NEPEAN HOSPITAL & INTEGRATED AMBULATORY SERVICES REDEVELOPMENT STAGE 2

(SSD-16928008)

ARCHITECTURAL DESIGN STATEMENT RESPONSE TO SUBMISSIONS

29th of April 2022
2 of 18
ISSUE B

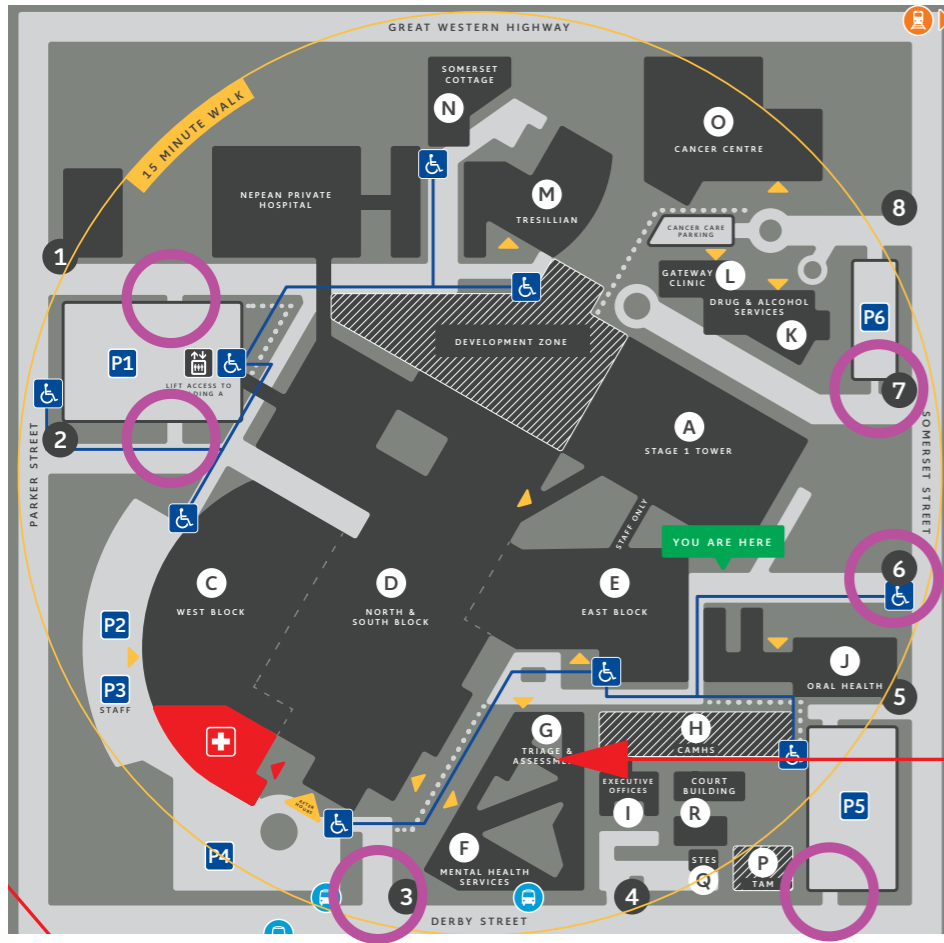
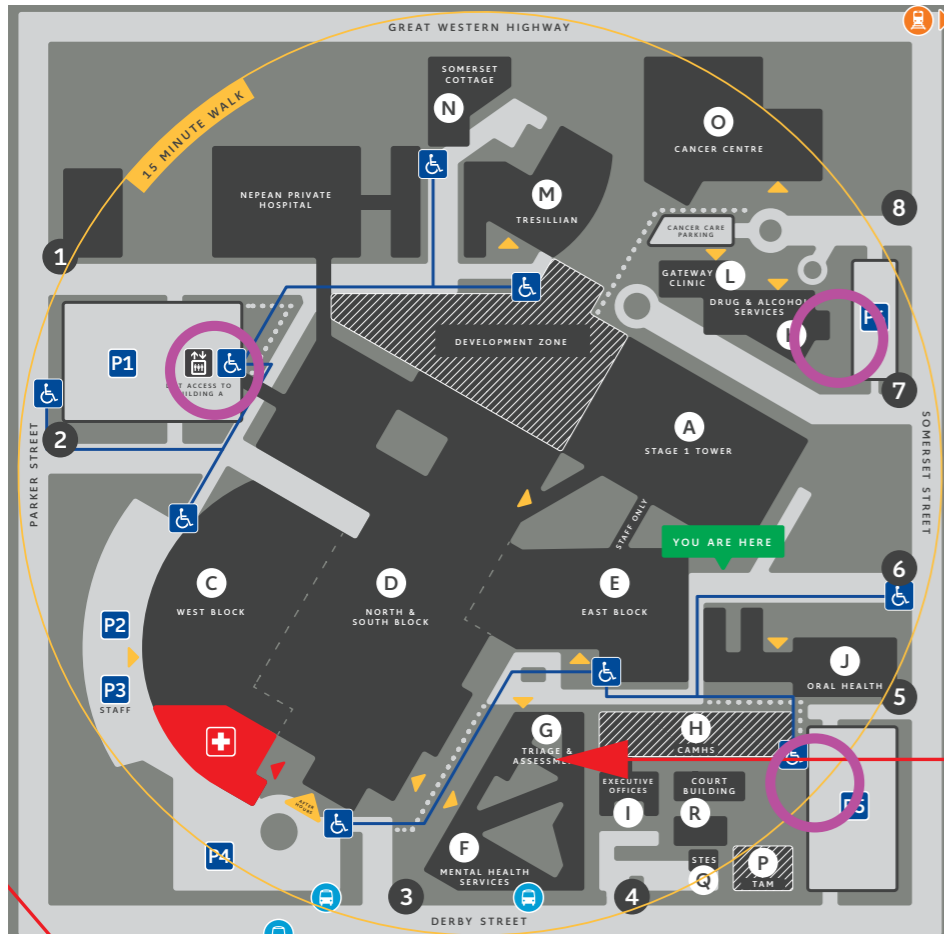
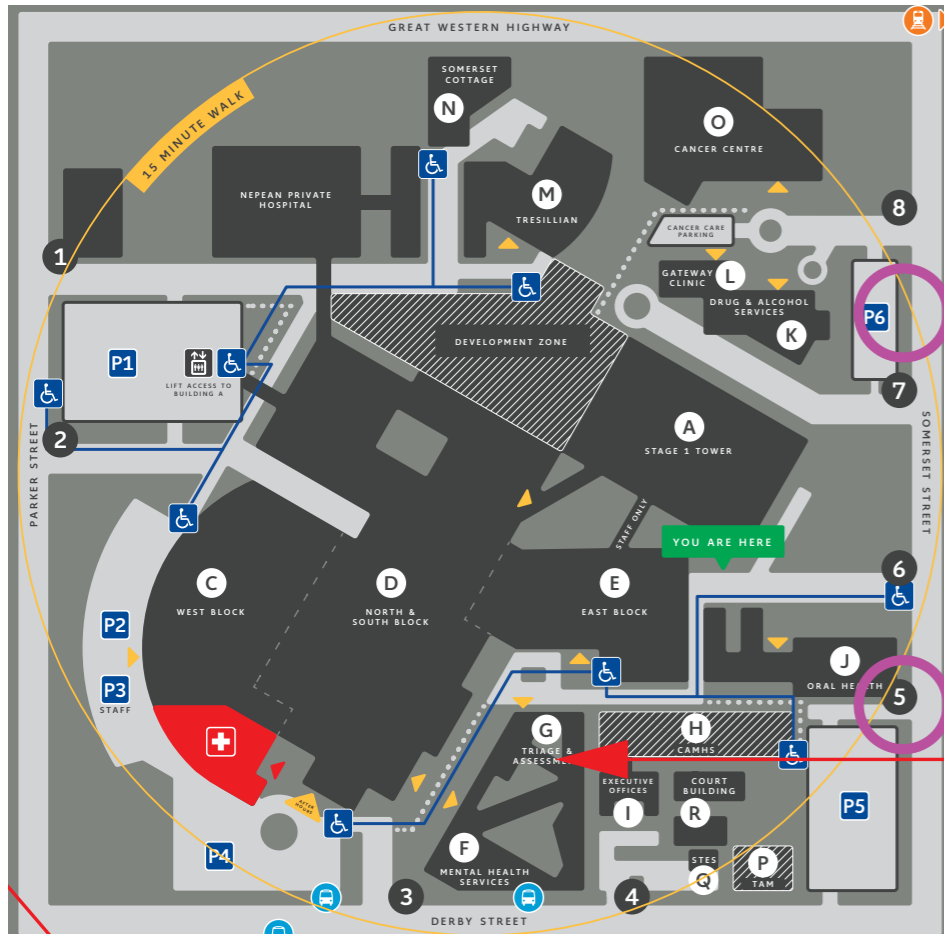
- From an emergency response perspective, EES notes that, the College, Orth and Werrington Creeks Catchment Overland Flow Flood Study (June 2017) and the draft College, Orth and Werrington Creeks FRMSP 2021 classify the hospital site as a ‘flood exit route rising road’. However, it is prudent to consider that the access through the Great Western Highway at the north eastern corner at the hospital will be cut in major events for a short duration. Safety signs may be required to guide the community and health services to avoid this route in major flood events.

- Signage proposal by Urbanite to address safety concerns in major flood events.
